Our Ref: P/58/19/PL

**Town & Country Planning Act 1990 (as amended)
Town and Country Planning (Development Management Procedure) (England) Order 2015
Application for Planning Permission**

Development Erection of 9 No. dwellings with associated access, parking, cycle & refuse storage & landscape design. This application is a Departure from the Development Plan & may affect the setting of a listed building.

Location Rear of Inglenook Hotel 253-255 Pagham Road Pagham

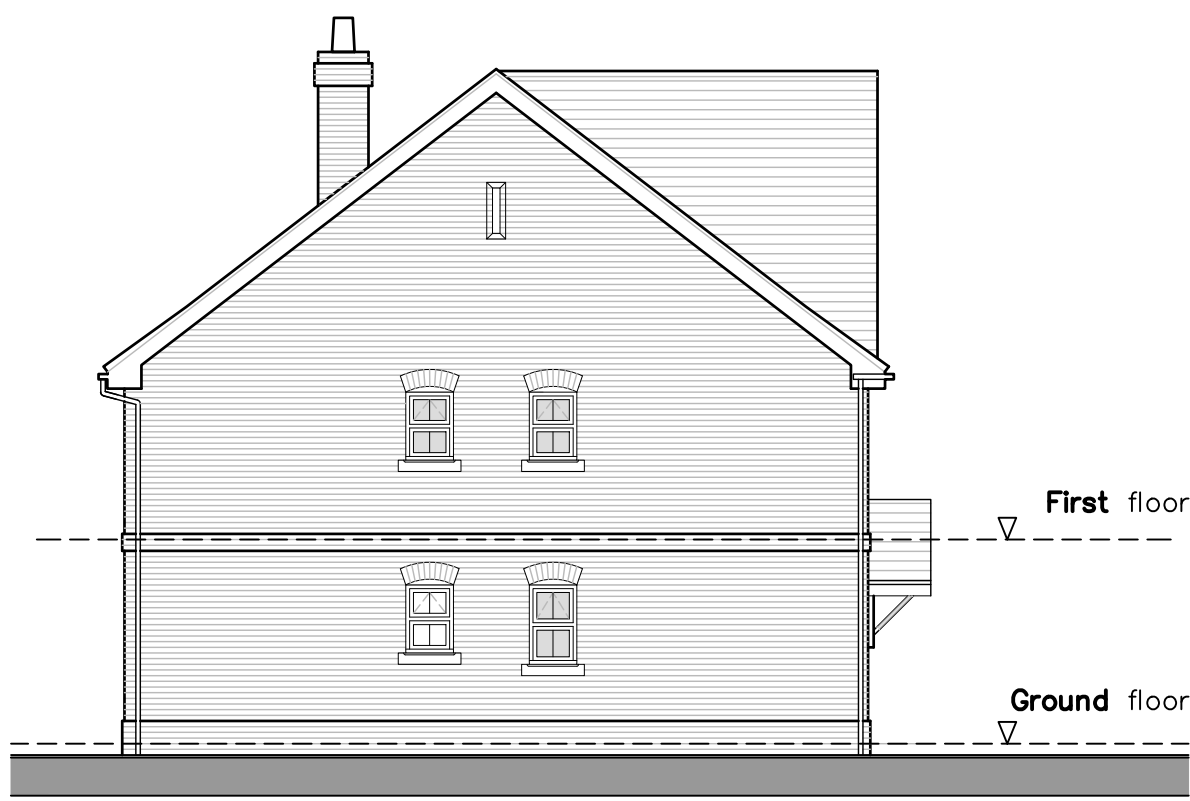
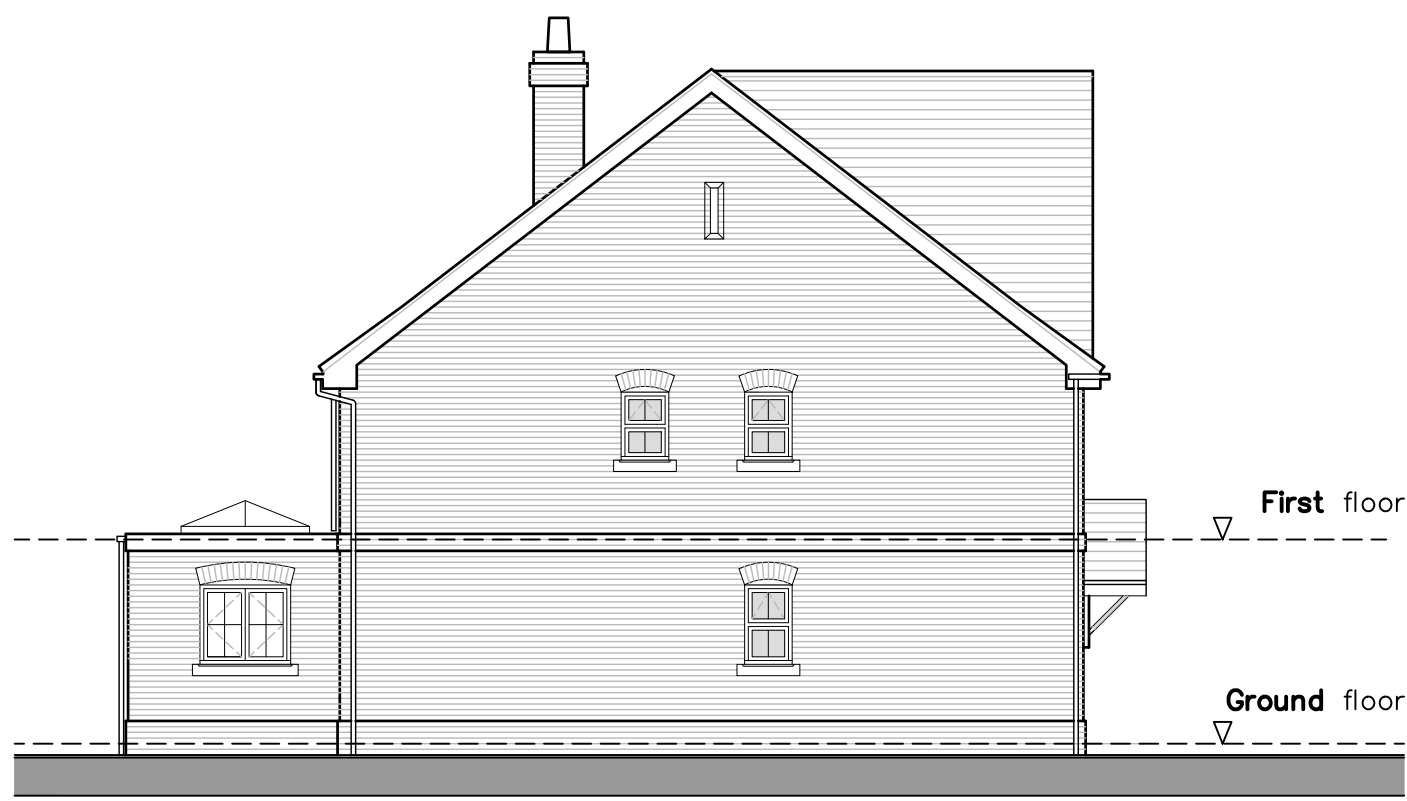
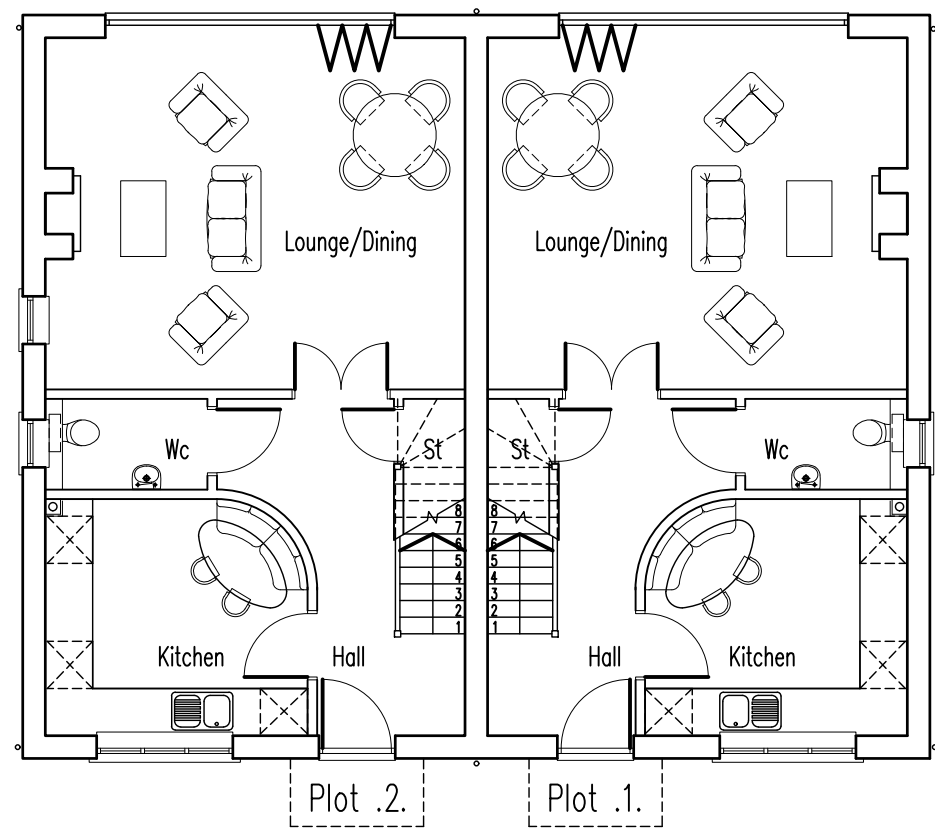
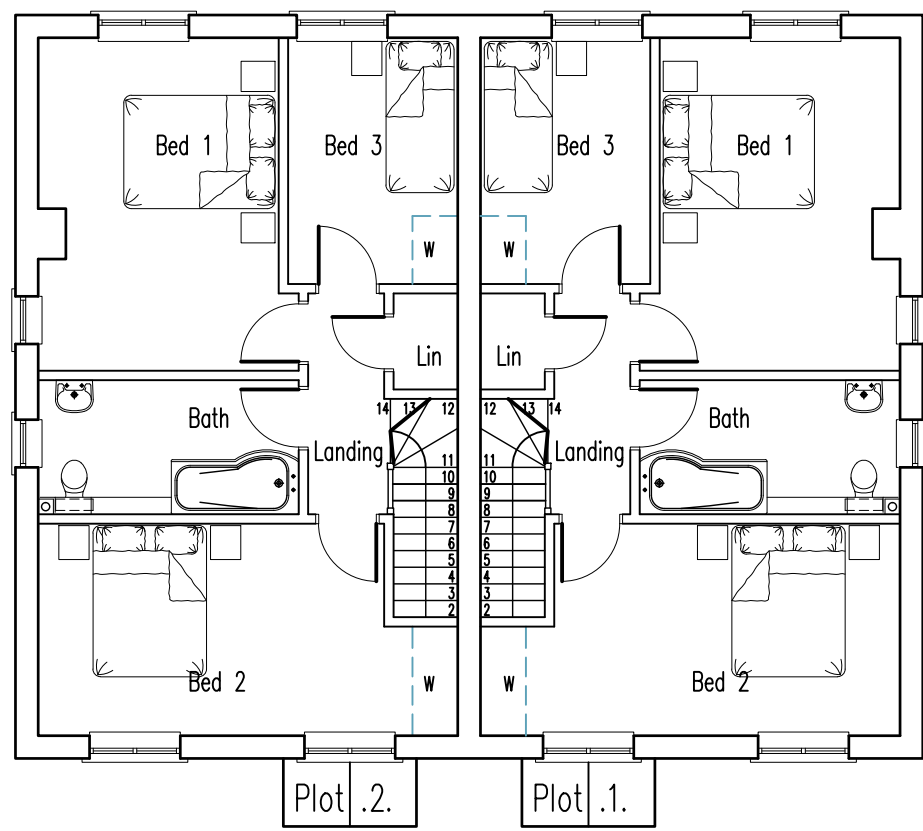
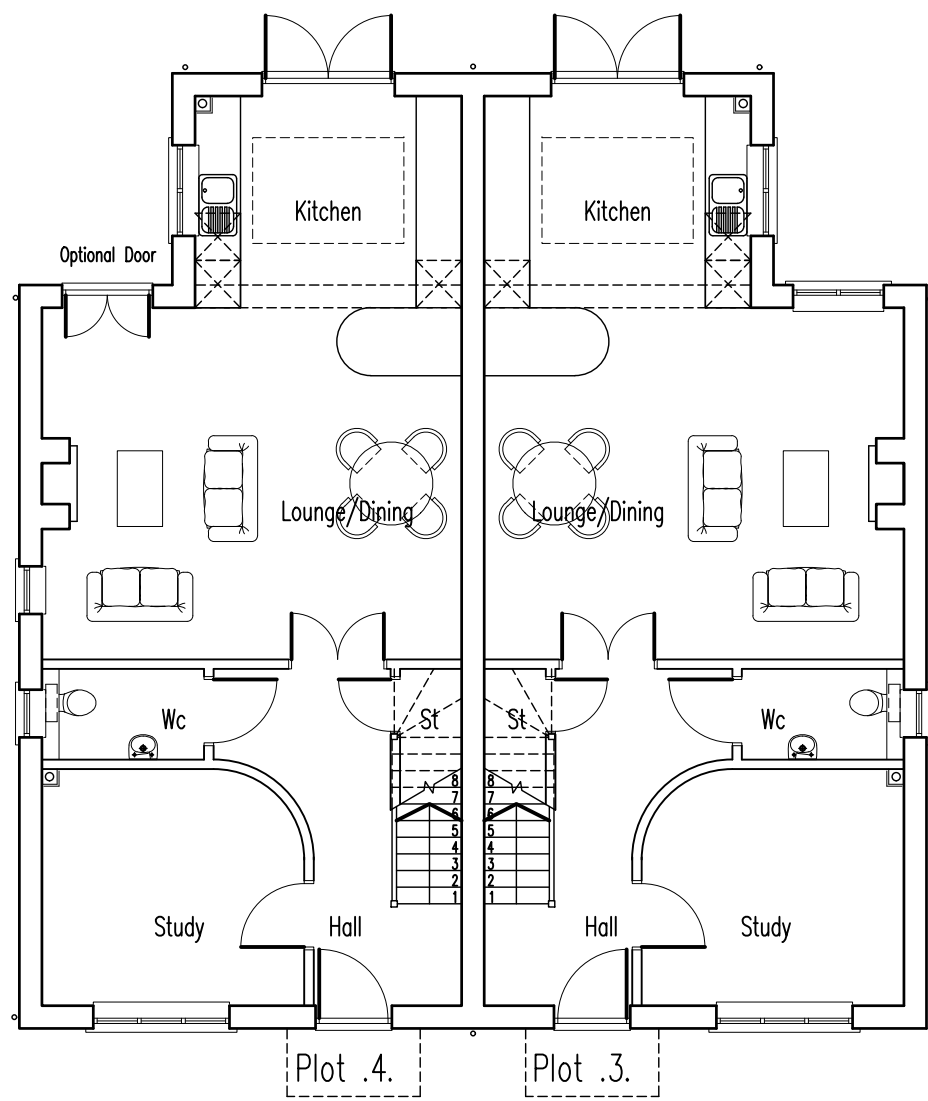
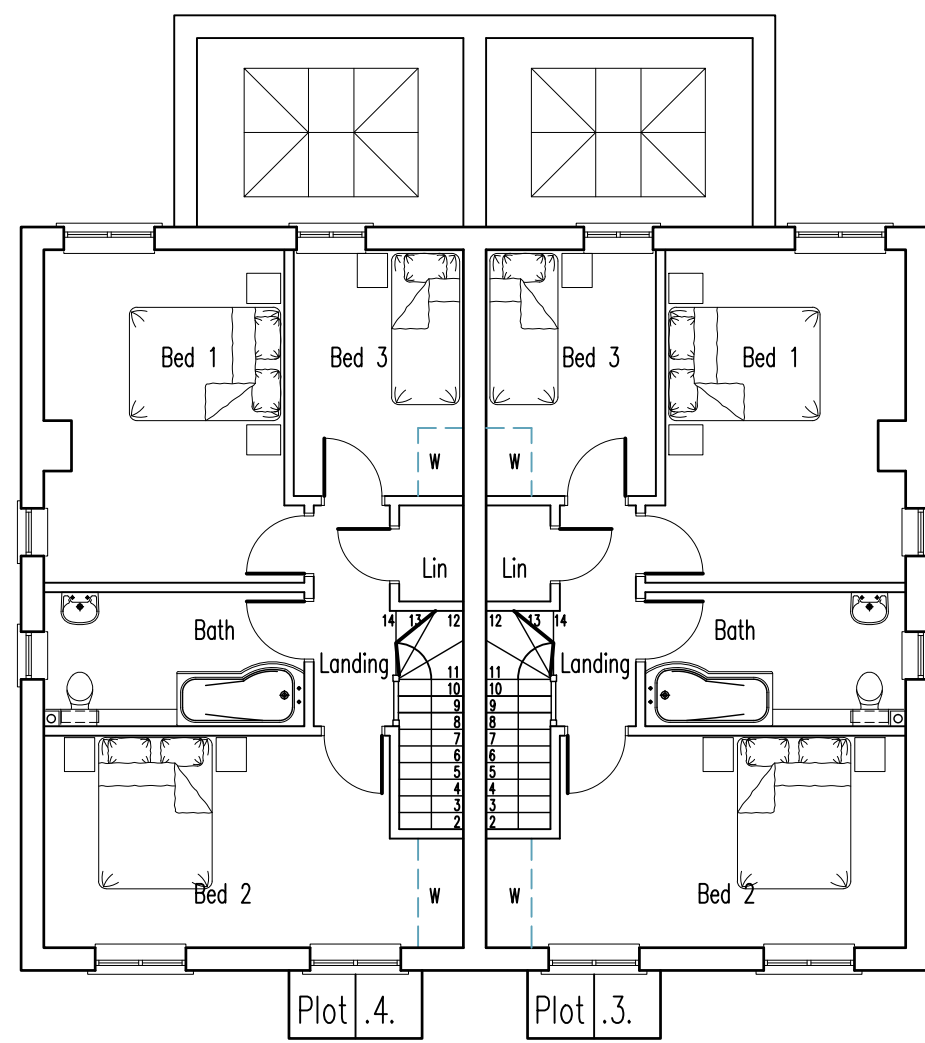
On units 1 and 4, the side elevations and ground floor plans do not accord. Please amend accordingly.
